Our ref: 24/06269#97

Your ref: SSD-48225958

Subject: Gundry Solar Farm

The Department of Planning, Housing and Infrastructure – Crown Lands has reviewed the proposal.

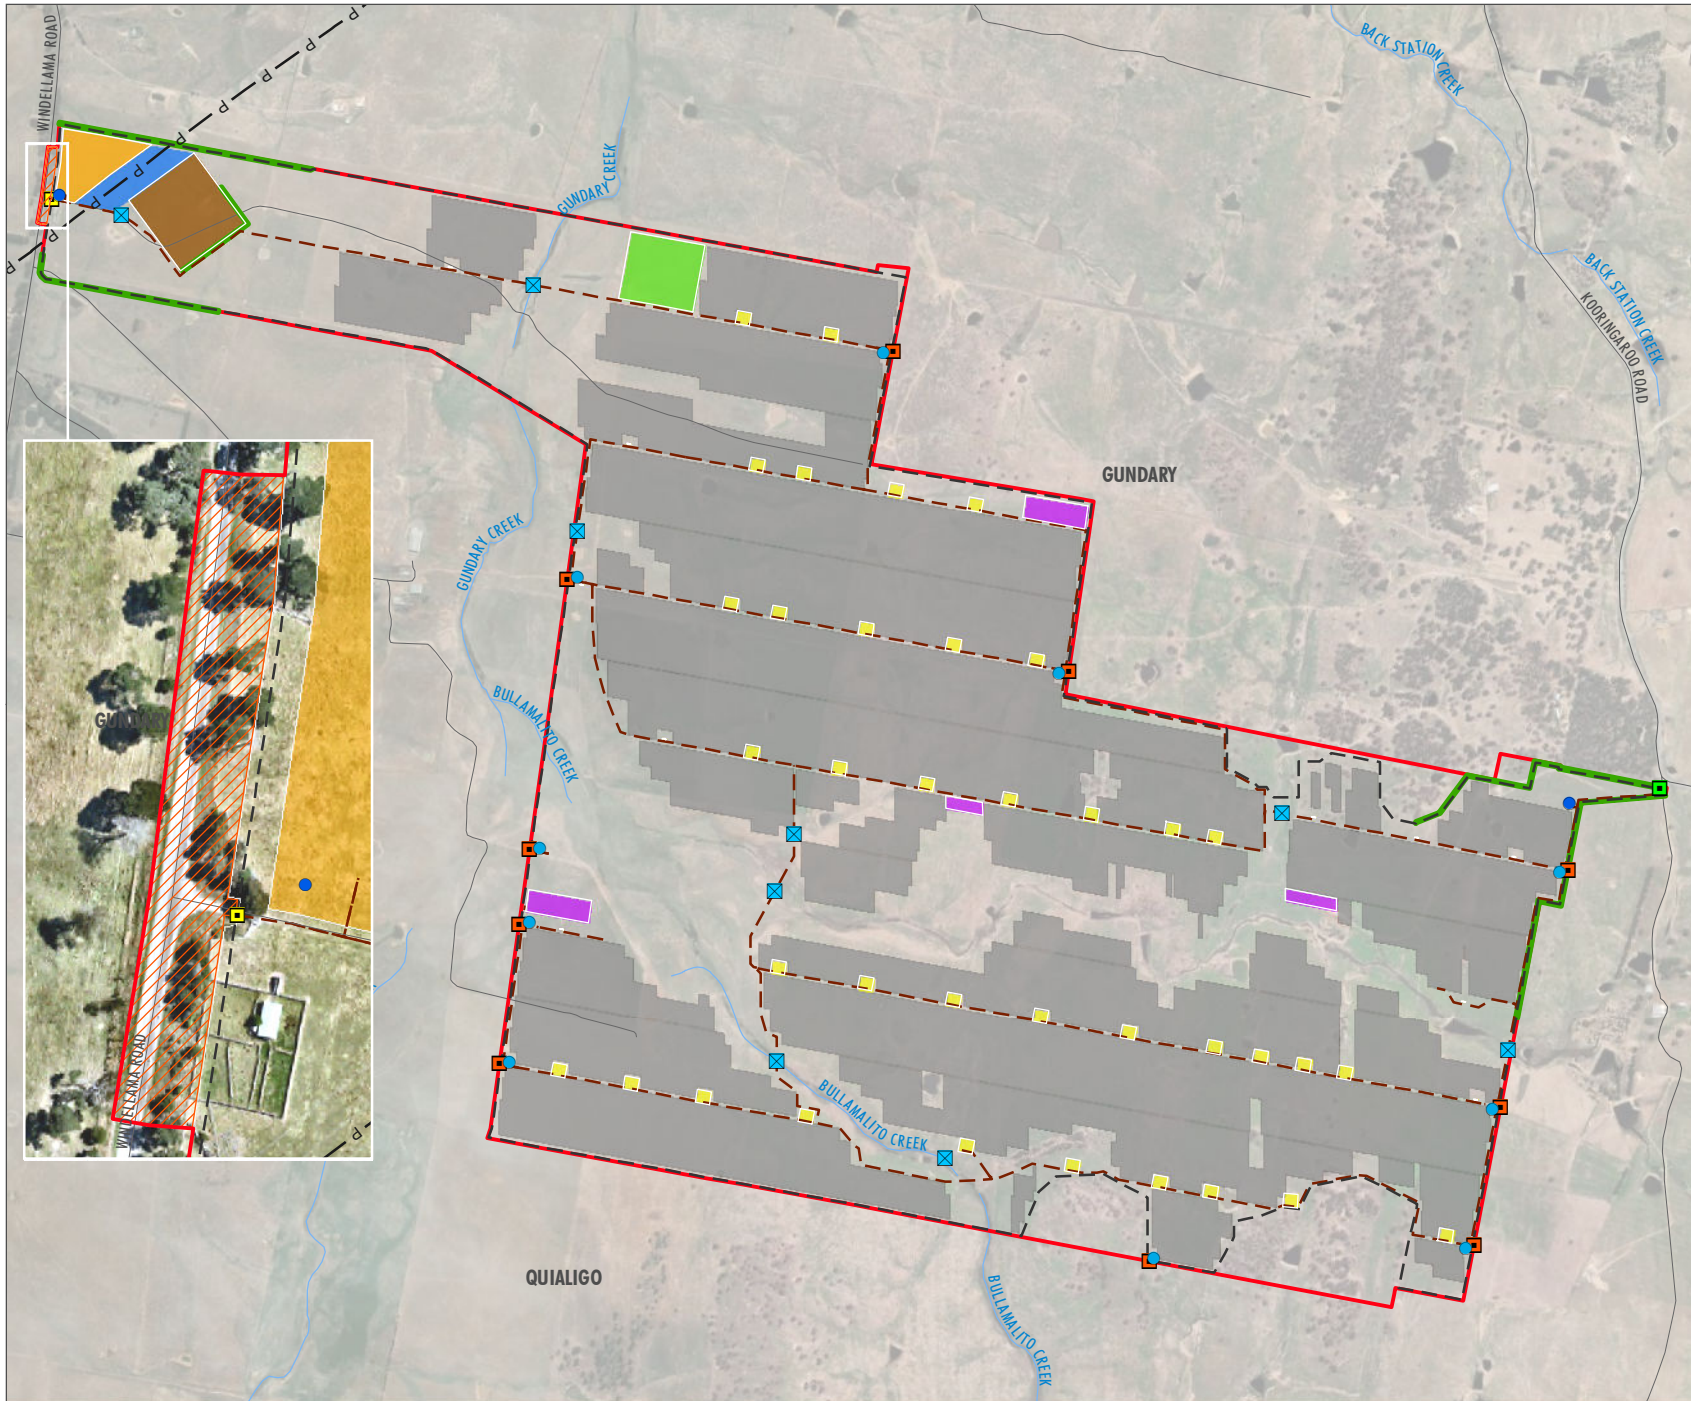
As per Figure 3.1 - Project Conceptual Layout - Gundry EIS Final Report, Crown Lands notes that the Gundry Creek and Bullamalito Creek traverses through the project area and that it is intended to construct internal access tracks comprising of culverts and/or bed level crossings as well as installing security fencing over the waterway.

As per section 3.1 - Project Conceptual Layout - Gundry EIS Final Report, Crown Lands makes shows an internal access on/near the boundary of the Crown Road that adjoins the northern boundary of Lot 12 DP 1016332.
